# TRAFFIC IMPACT STUDY

DATE:  
July 10, 2023

PCD File No. CS224

Owl Place Storage  
El Paso County, CO

**Attachment I**  
**Site Plan**  
**Truck Turn Exhibit**

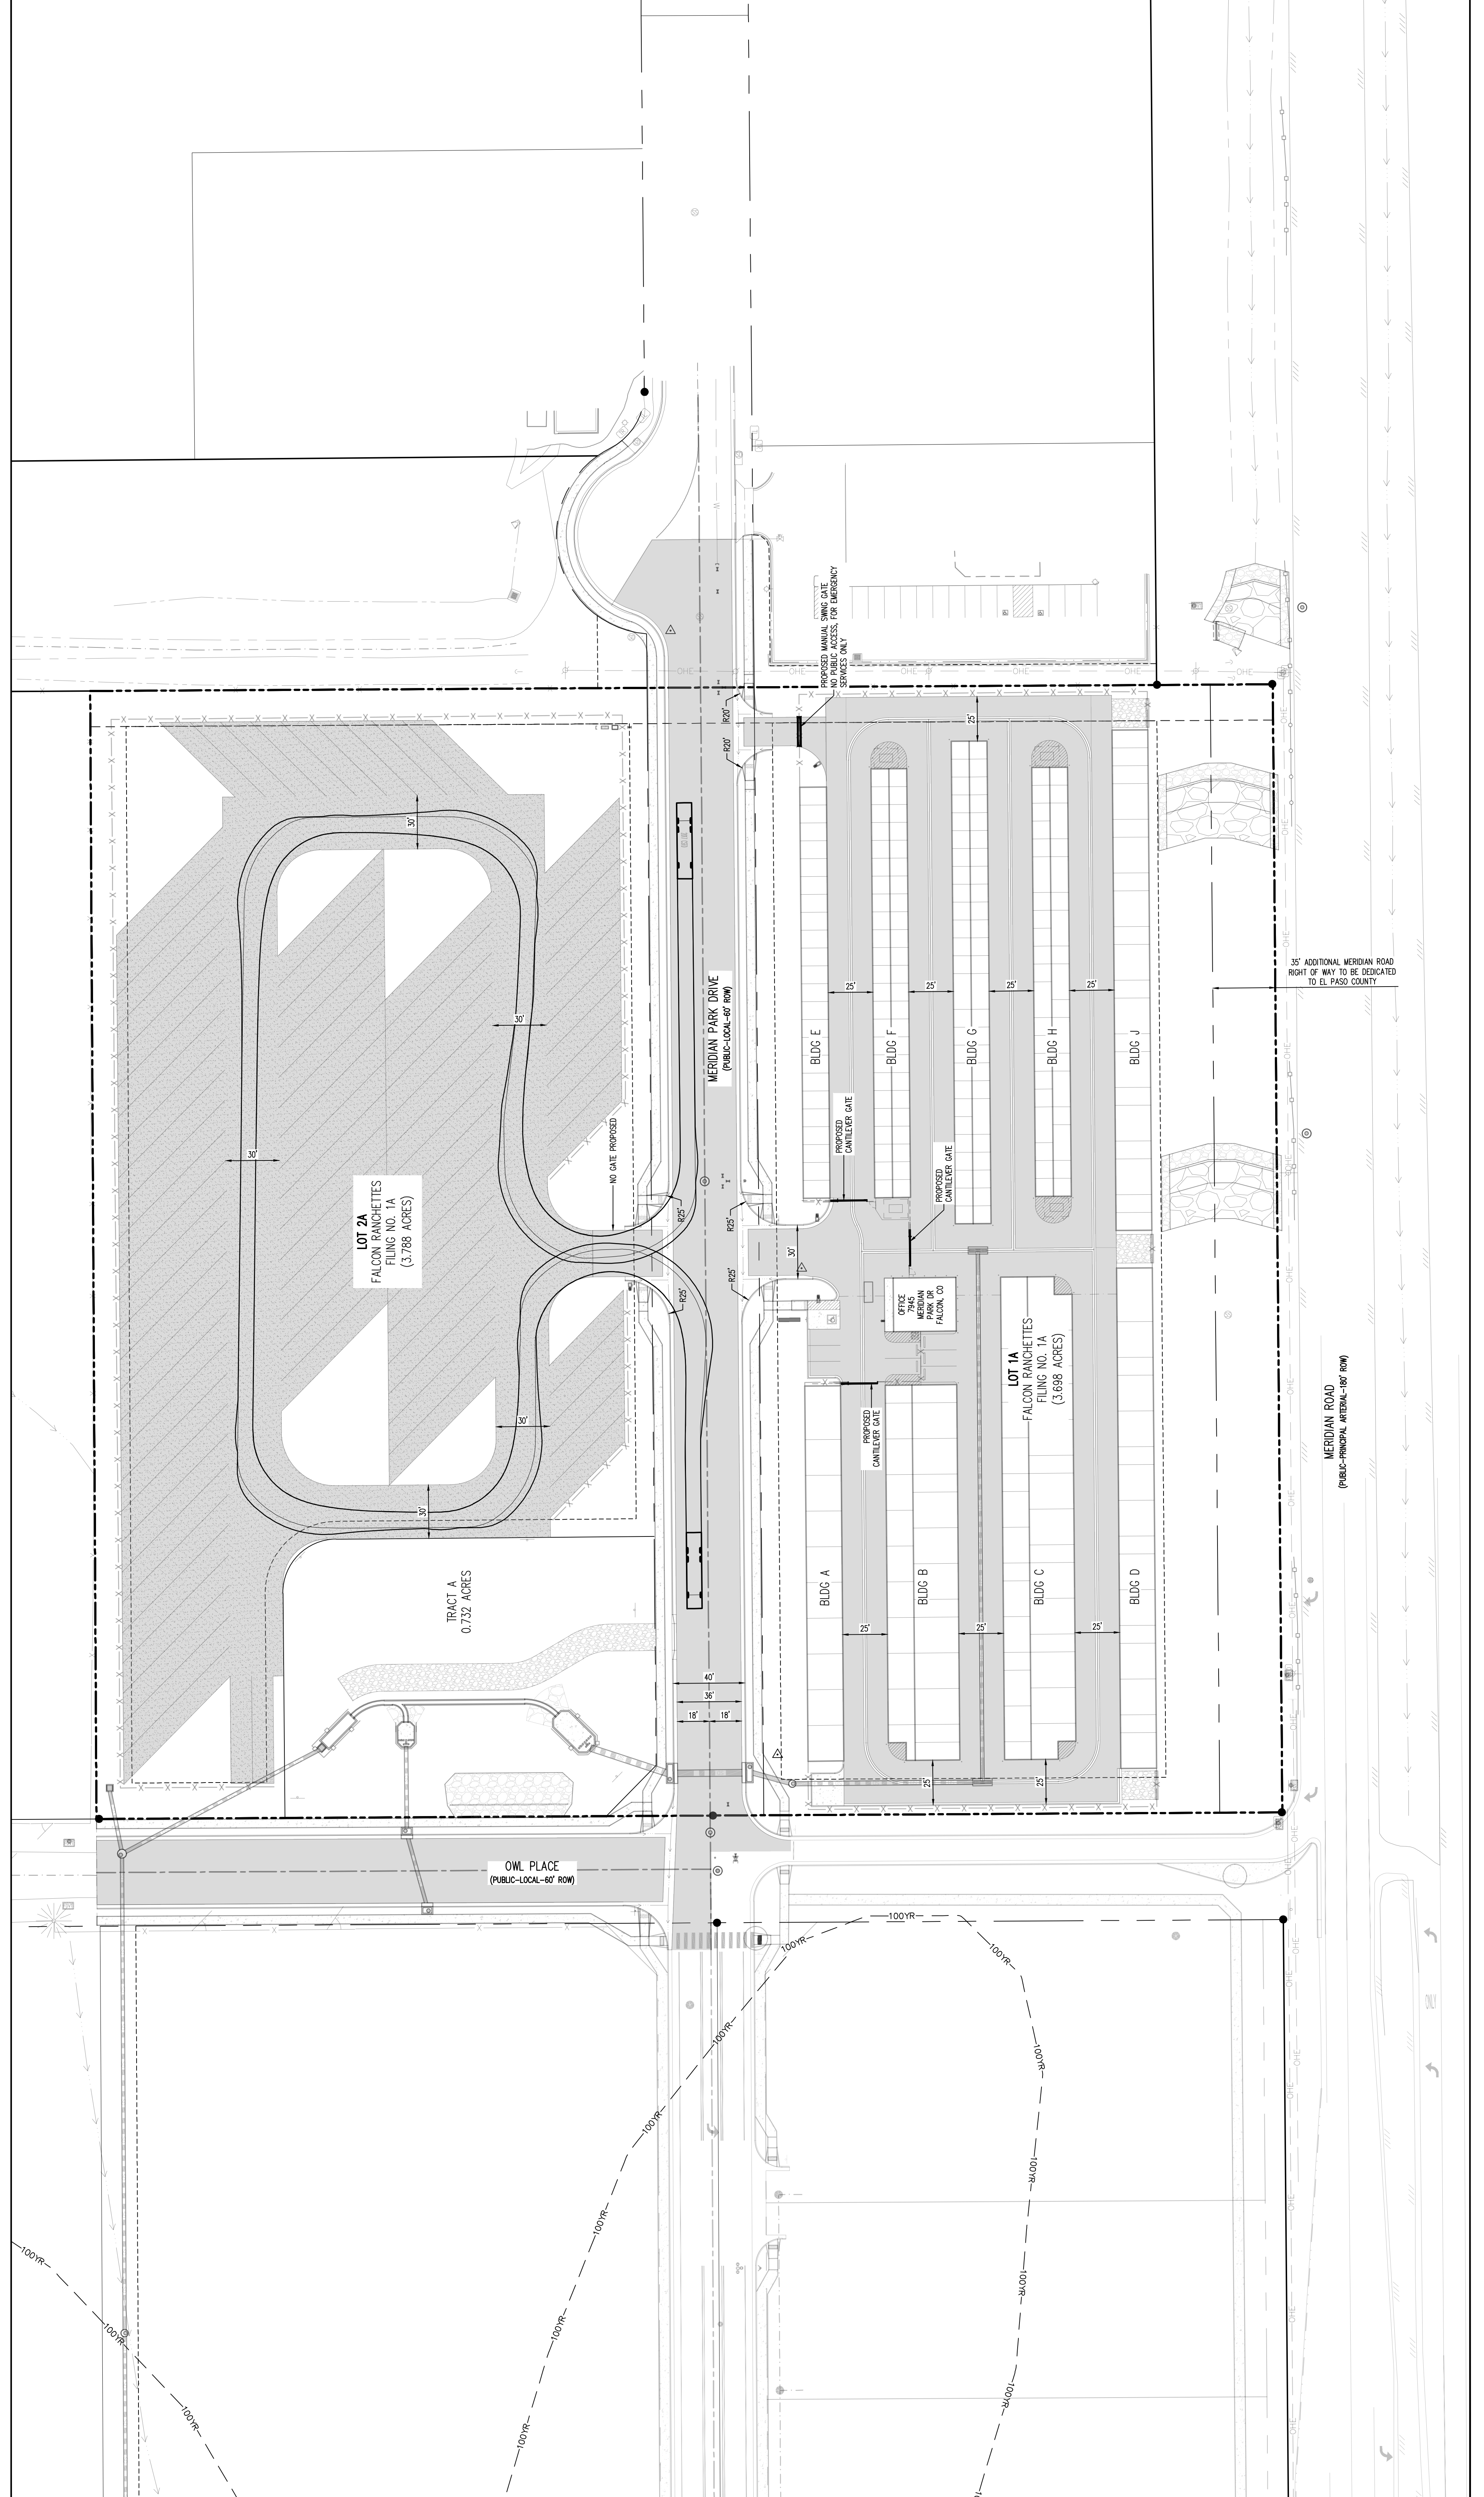
Additionally, provide recommendations for curb return radius providing the appropriate Autoturn analysis for the design vehicles for the RV/boat storage access.
